From: [NectonSubstationAction Messenger](#)
To: [Norfolk Boreas](#)
Subject: Norfolk Boreas Project – EN010087
Date: 21 November 2019 09:34:44

Our answer to Q5.3.3 in <https://infrastructure.planninginspectorate.gov.uk/wp-content/ipc/uploads/projects/EN010087/EN010087-001245-NORB%20-%20Written%20Questions.pdf>

It was explained by the Applicant at the DCO ISH on 13 November 2019 that in its opinion it is not necessary to limit all but the converter halls to 13m because the visual assessment has taken into account all the substation buildings development up to a height of 19m (parameter of the Rochdale envelope). The opinions of other IPs are requested.

Requirement 16 (5)
Buildings must not exceed 19m

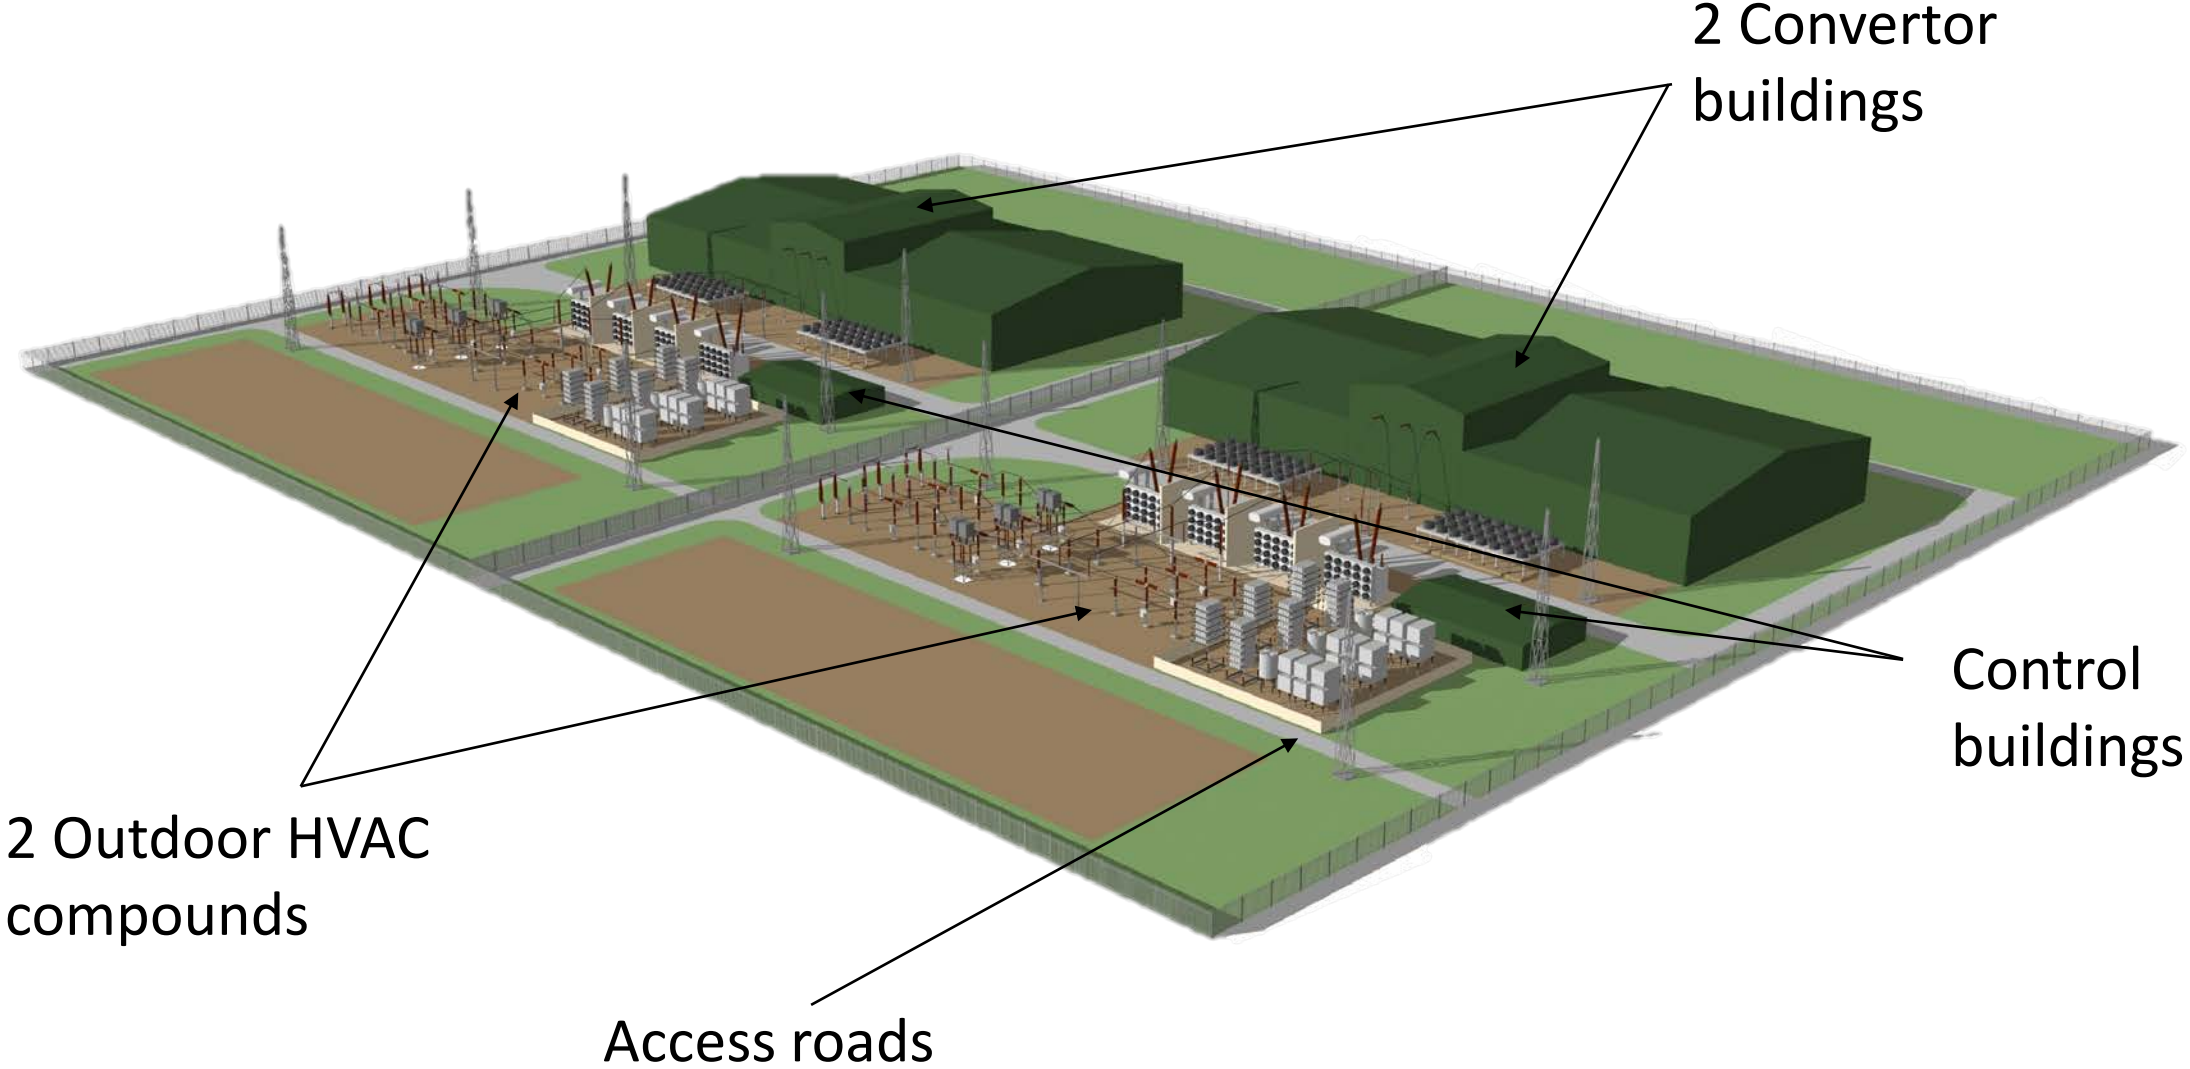
We disagree with the Applicant. It is ridiculous to assume that any buildings or structures exceeding 13m will not make a significant extra impact on the visuals of the substation. Mitigation is already impossible and will become only more so the more tall structures there are.

Requirement 16 (5)
External electrical equipment must not exceed 25m

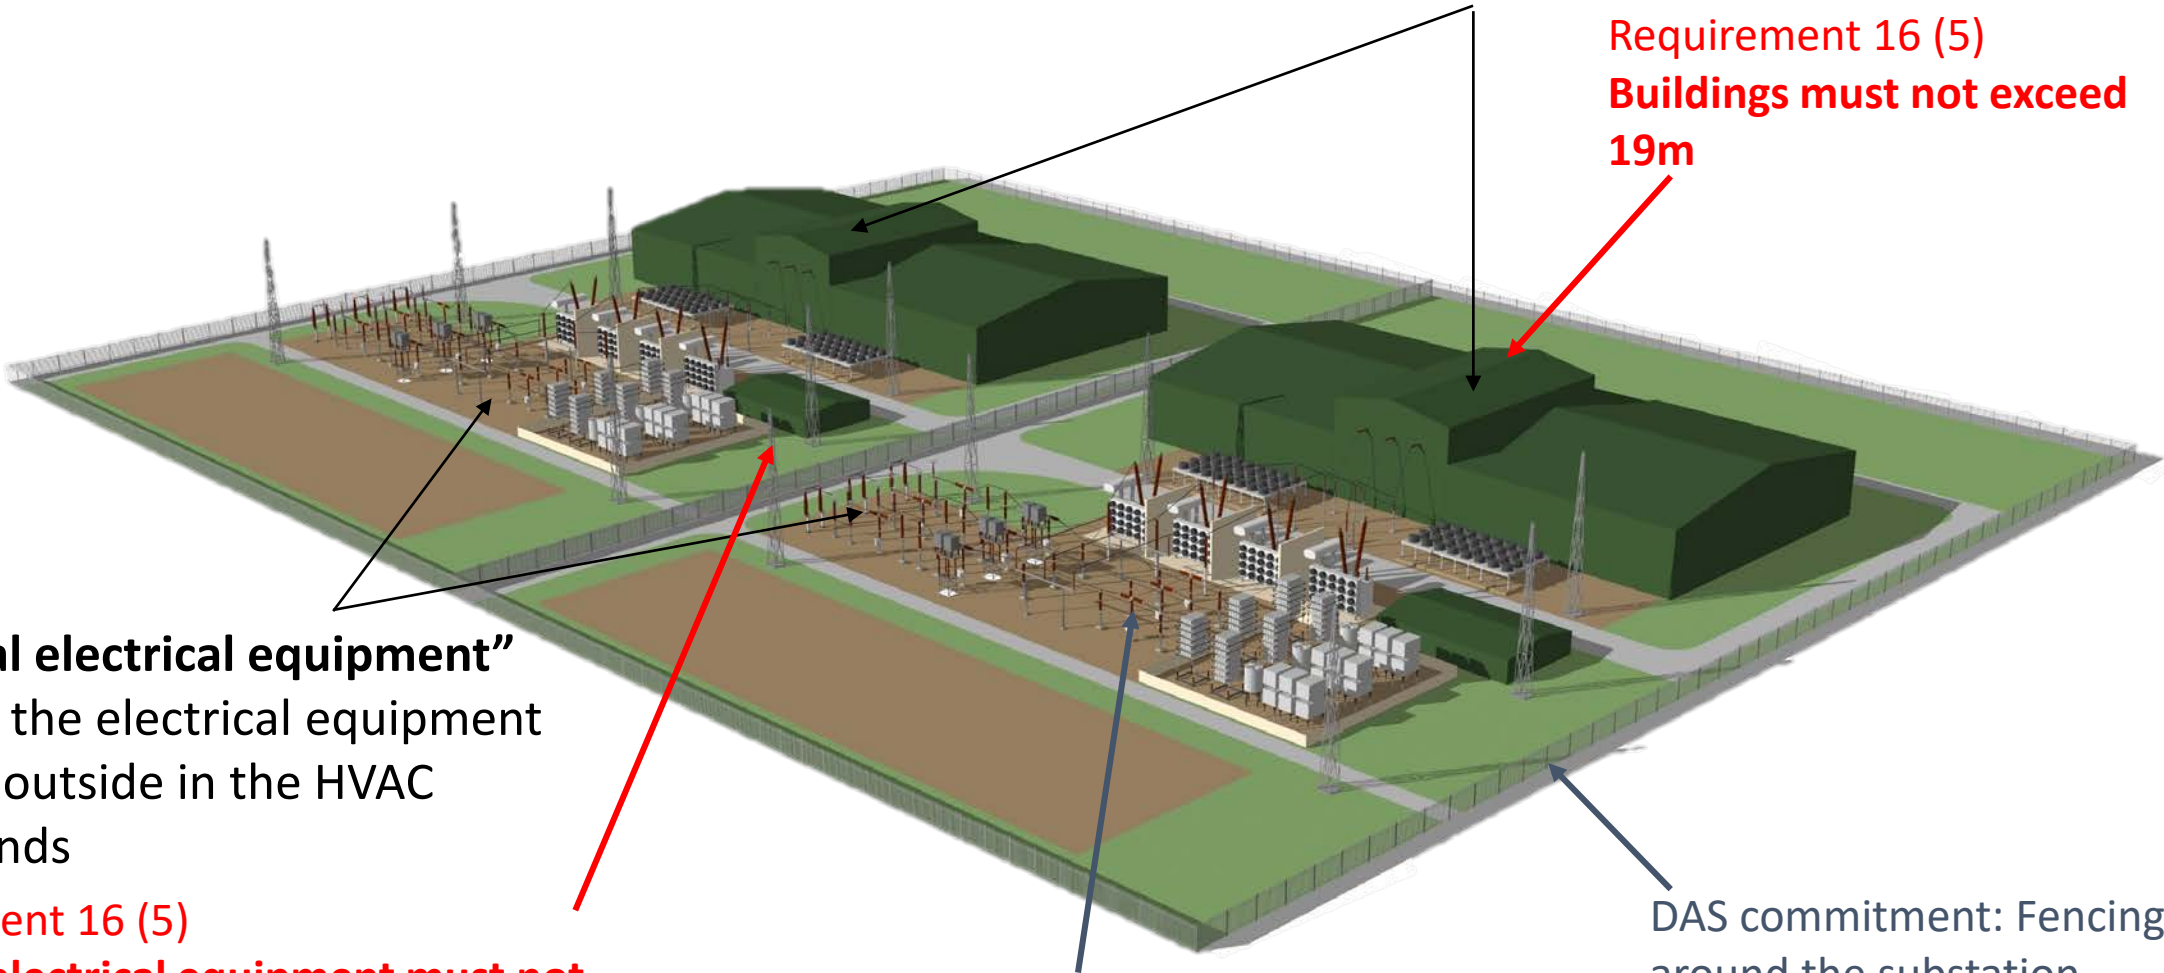
For example, the lightning conductors (which are more considerable in their bulk than one might imagine) will (we are told) be required for each and every building. We were told by the developer that these will be **25m high** (so higher than even 19m) and will be completely impossible to mitigate. Their materials will create sun-sparkle, ensuring that they will be seen by far distant receptors as well as those closer, and will be intensely irritating. They may apparently be connected by some kind of mesh (no-one from the applicant was able to give a definite answer on this at the presentations either for Vanguard or Boreas. This mesh (if it is used) will be a hazard to wildlife as well as a visual irritant.
